**Cambridgeshire County Council (20031358)**  
**East Cambridgeshire District Council (20031149)**  
**Suffolk County Council (20031377)**  
**West Suffolk Council (20031311)**

The Councils' Comments on Documents Submitted at  
Deadline 7

**Sunnica Energy Farm (EN010106)**

13 March 2023

### **I.1                      Works Plans**

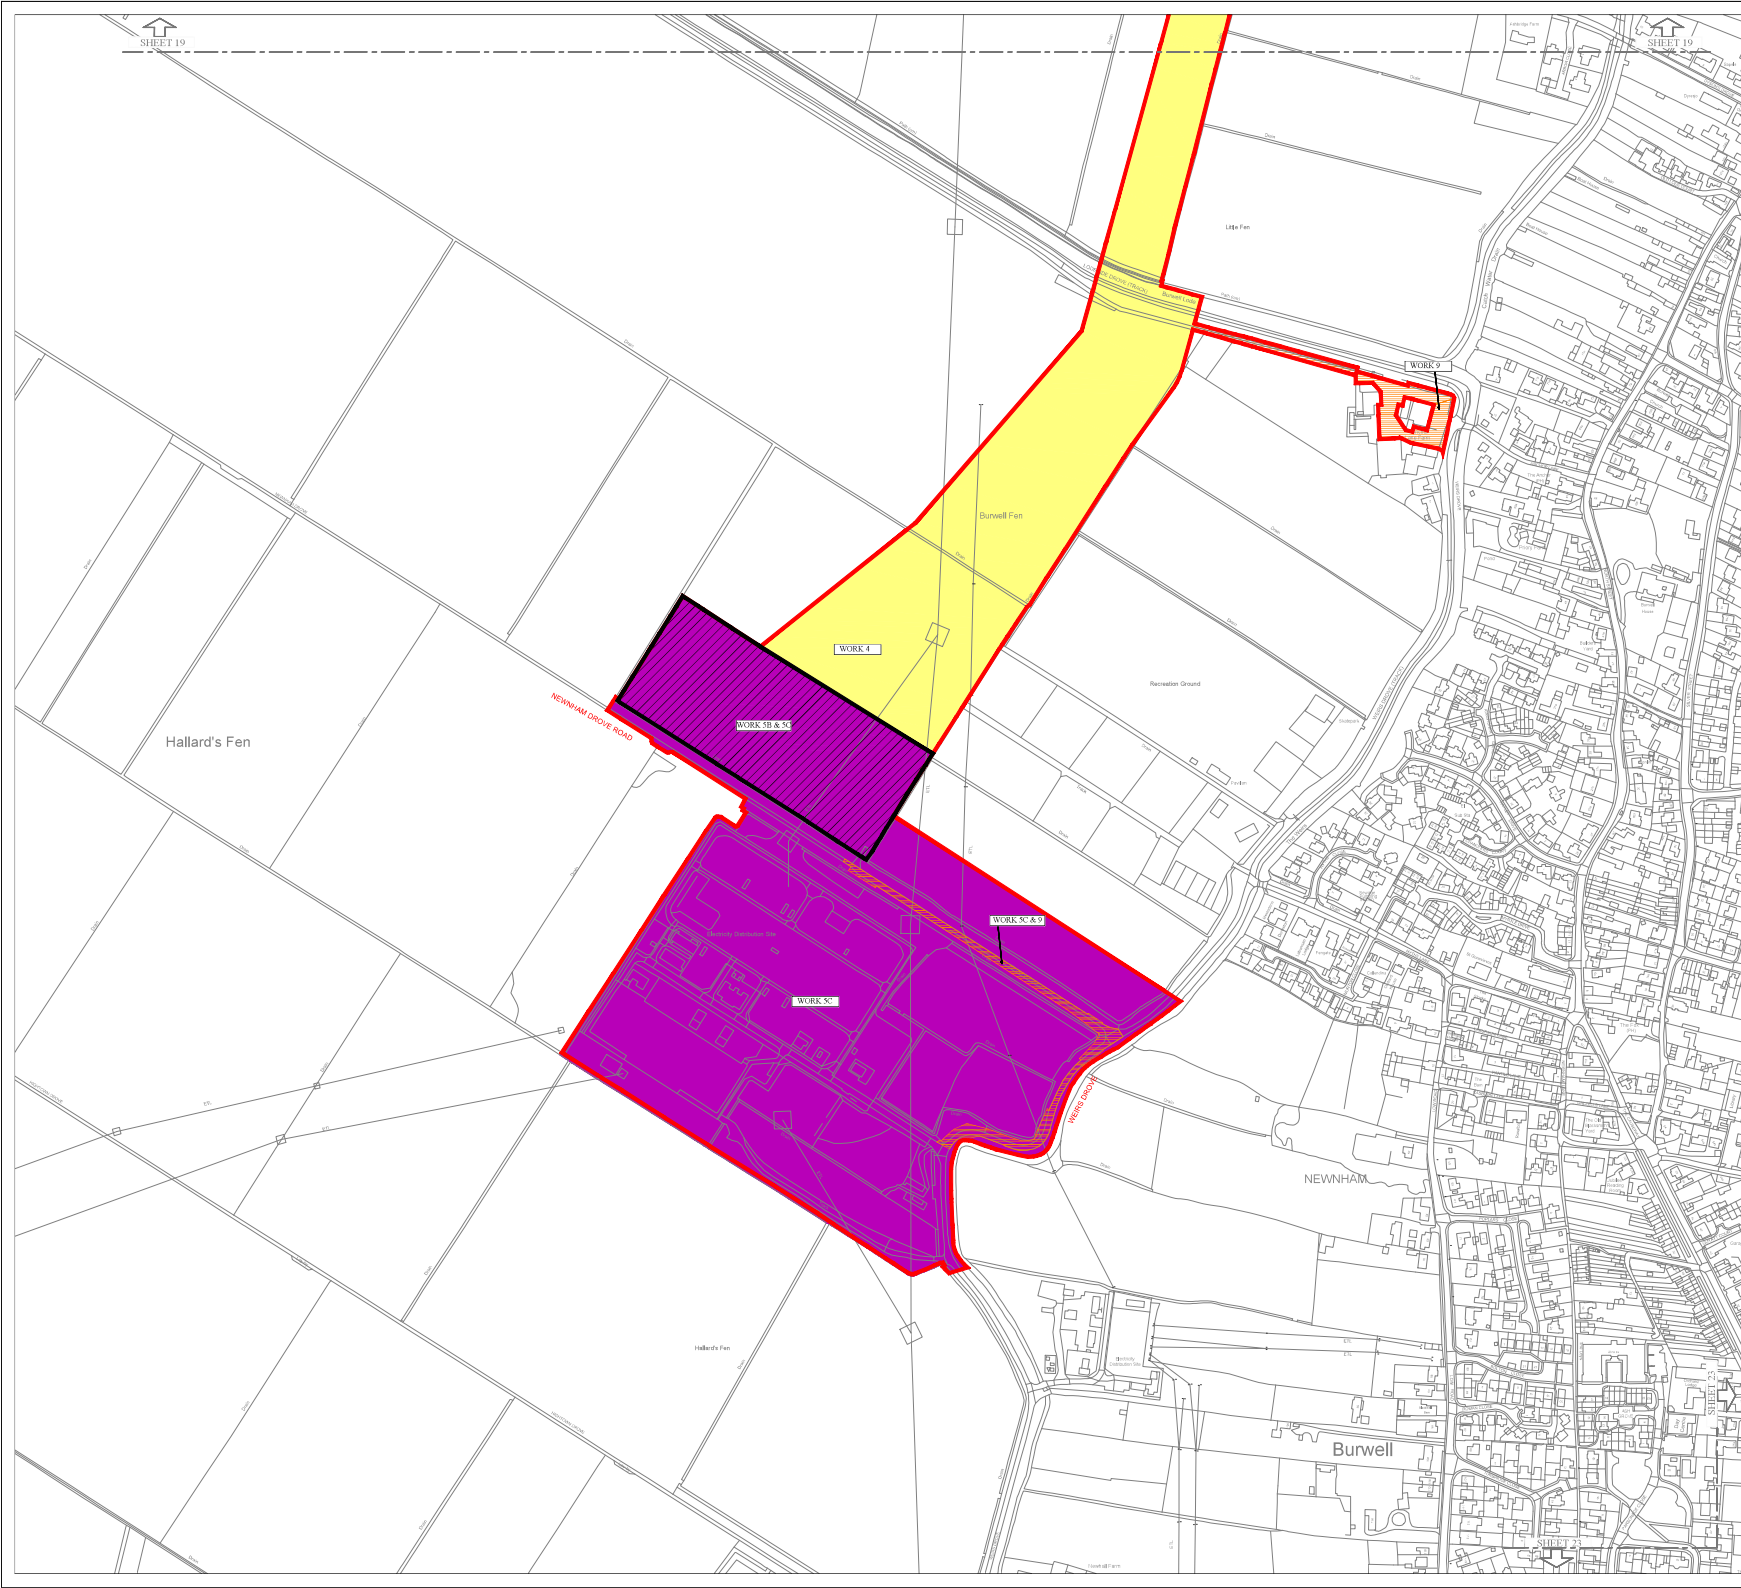
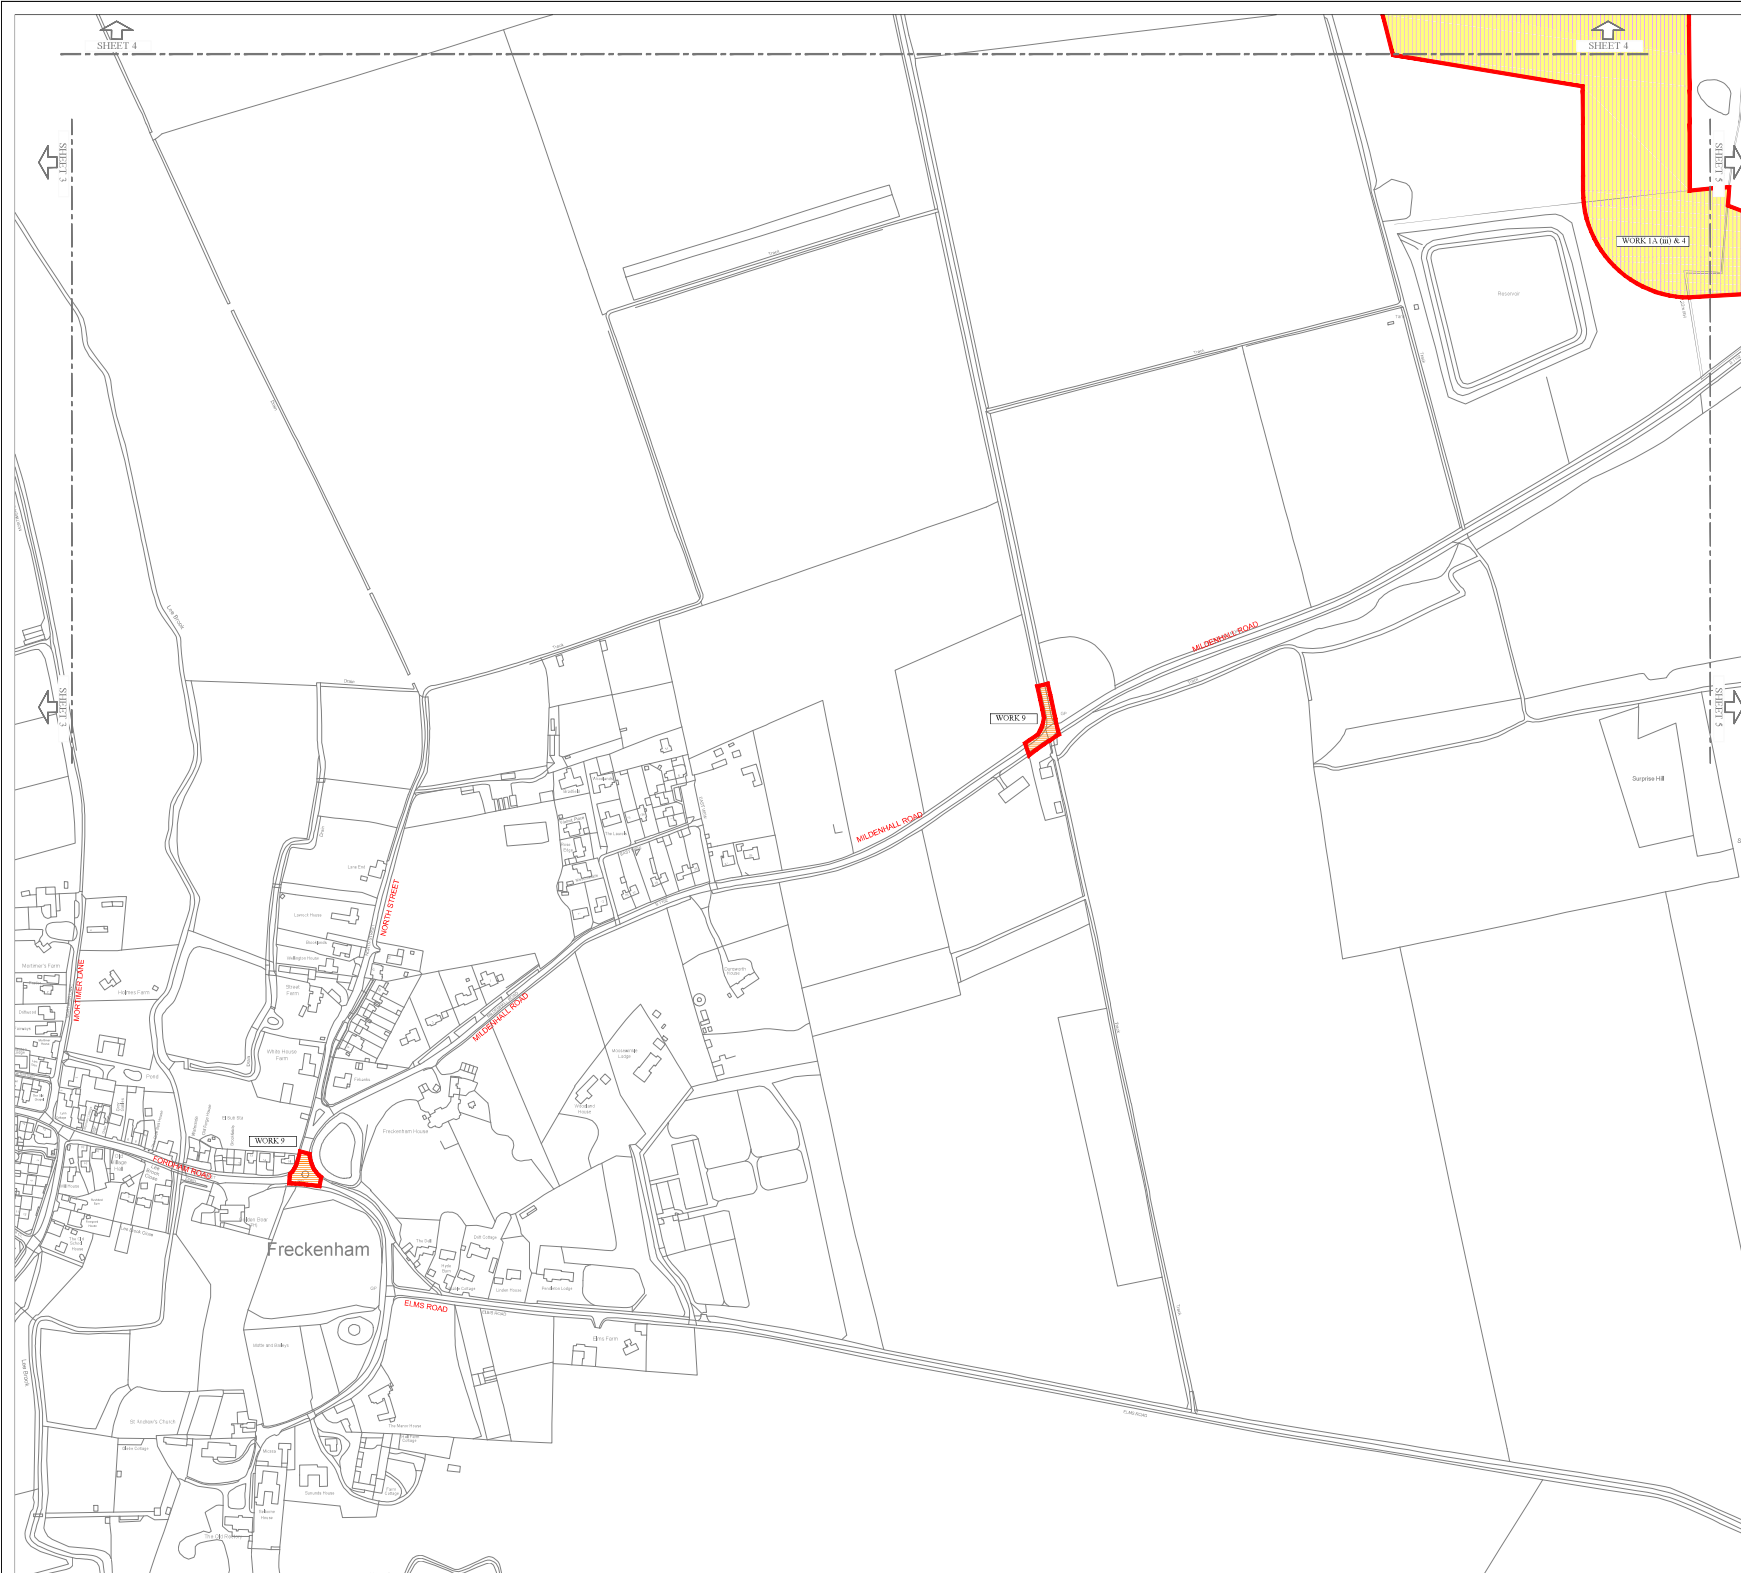
14. With regard to the cable corridor, where this falls within Work No. 4 (which the Councils' Proposed Amendments leave unchanged), there was no need for the Proposed Amendments to address the cable corridor. The Works Plans [REP7-004 contains the most recent revision 05 of the Works Plans] show the corridor for Work No. 4 within the specified parcels, and the definition of Work No. 4 (and all other numbered Works) in Article 2(4) of the draft DCO incorporates the information shown on the Works Plans. Article 3(2) of the draft DCO requires any numbered Work to be situated within the corresponding numbered area shown on the Works Plans and within the limits of deviation. The Works Plans (in their final form) will become a certified document within Schedule 10 of the draft DCO. Where the cable corridor falls within the scope of Work Nos. 1A(iii), 1B(iii), or 1C(iii), the corridor for these Works is also shown on the Works Plans and the definition in Article 2(4) in conjunction with the terms of Article 3(2) would also apply to limit the areas where such works (if required) could be undertaken. In any event, if further detail of the cable corridor were to be required to be shown on the Works Plans there would not seem to be any great difficulty in incorporating the relevant parts of the information shown on the Cable Corridor plans in REP7-039 into the Works Plans.

22. The Work Plans have not been updated to show the additional landscape mitigation works (Work No 6) that are included in the Environmental Masterplan [REP7-054] and in the Applicant’s Deadline 7 Submission - 8.103 Landscape Mitigation Parcel Schedule. Further comments on these documents can be found in Annex B.
